18 December 2020

Re: Engineering Evaluation of Detached Structure, 17104 Goshawk Road, Geoquest #20-1162

**A2** ENDWALL SECTION  
SCALE: 1/4" = 1'-0"

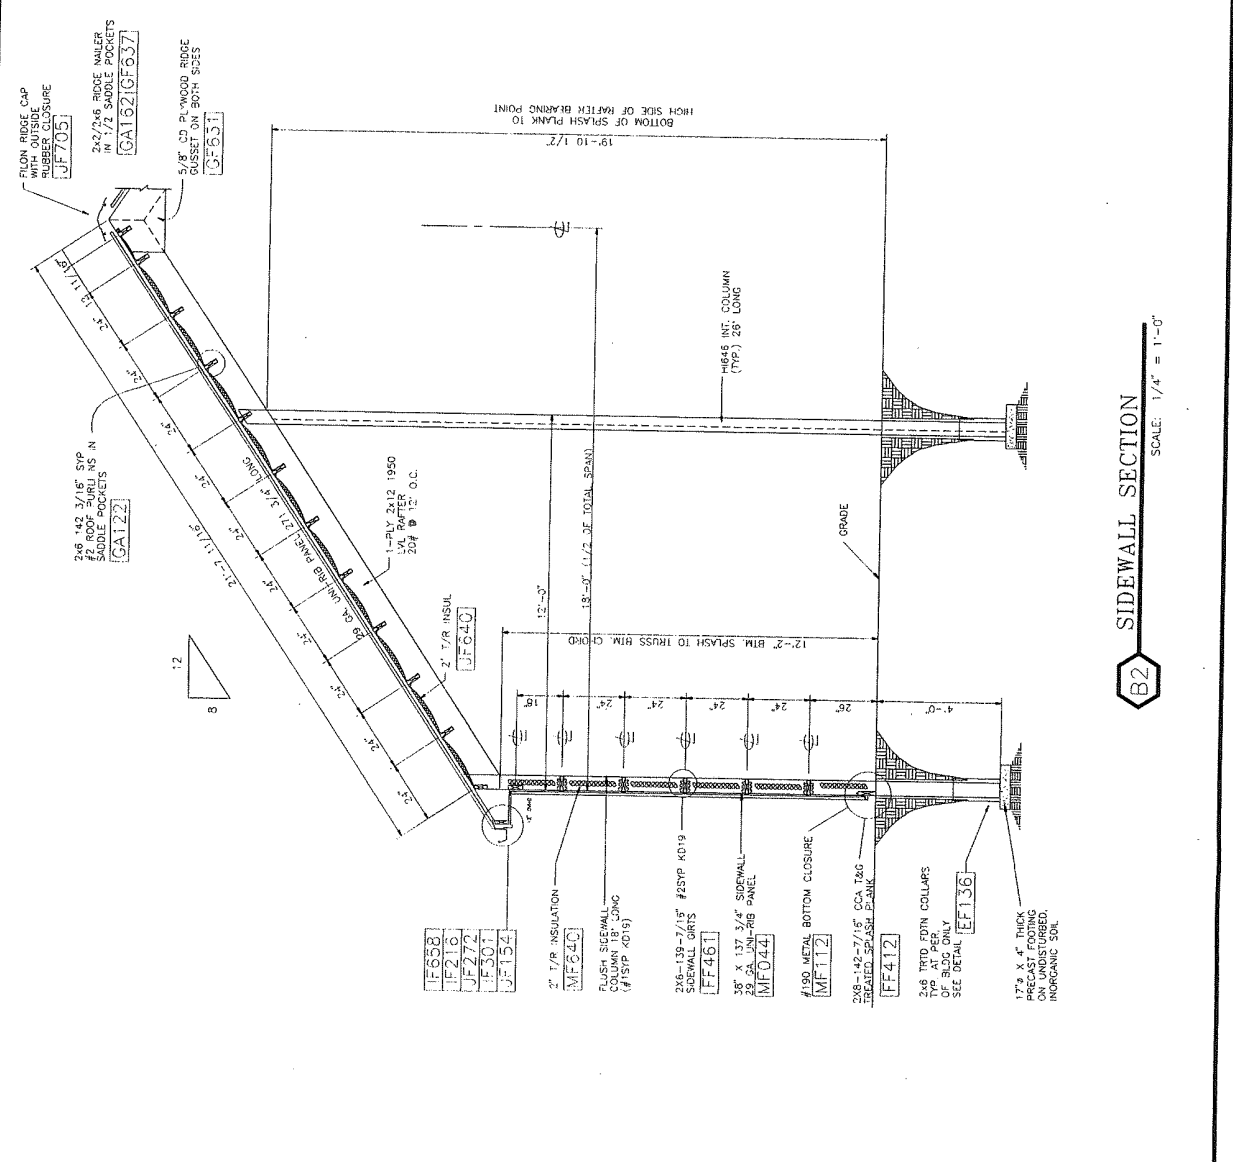
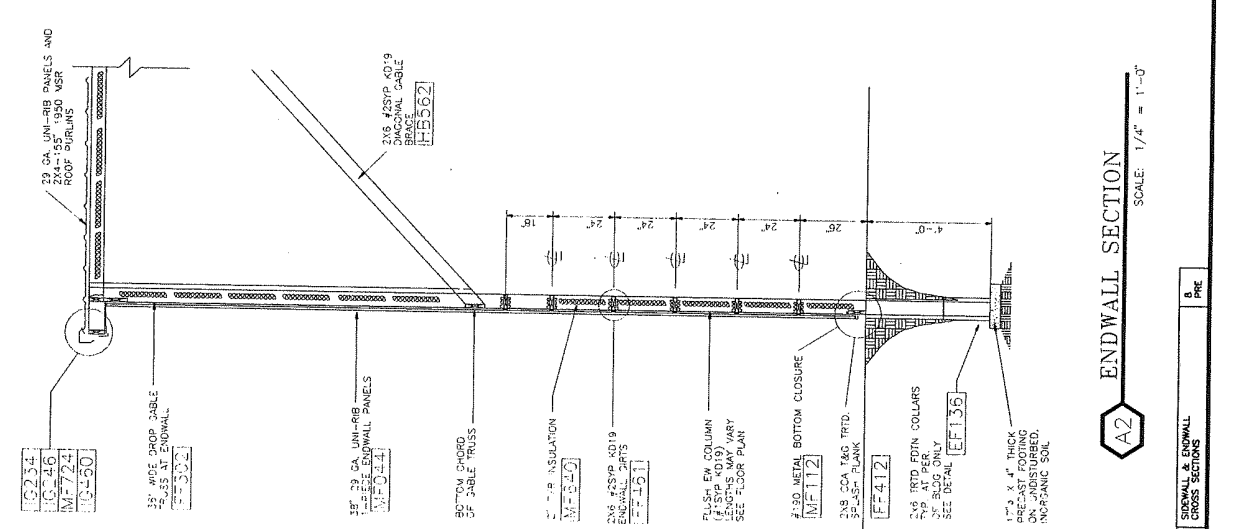
1. The floor framing is supported by a ledger to the structural columns with four 16d nails. This, for a span of 12' between the columns, is not adequate. Also, the single 2x12 ledger acts more as a beam than a ledger and is not adequate for the linear loading on the member.

2. The roof rafters are single 11-7/8" LVL's spaced 12" O.C. and were apparently designed for a 20psf snow (or possibly total) loading. The current requirement for snow load is 40psf with a dead load of 15psf, which means the existing rafters are well undersized.

3. The floor joists for the upper level are adequate.
4. The 17" diameter foundation pads under the structural columns are not adequate at any soil bearing we currently assign, 5,000psf maximum. No soil test is available to determine the actual size required, but since the structure was initially built without permit as an agriculture building this was not required. The age of the main house is such that no soil test would likely have been performed.

Since the structure has been in place for approximately 23 years and is performing well, we feel it would be appropriate to request a variance of the structural issues involved. The lack of perimeter insulation might be an exception to this, as it creates a danger of slab movement as well as increases the cost to heat and cool the facility. The final decision on these issues is up to the Pikes Peak Regional Building Department (PPRBD). If you wish for us to provide a set of specific recommendations to remedy any of the structural issues, we would be happy to do so but suggest you wait until a variance has been approved or denied.
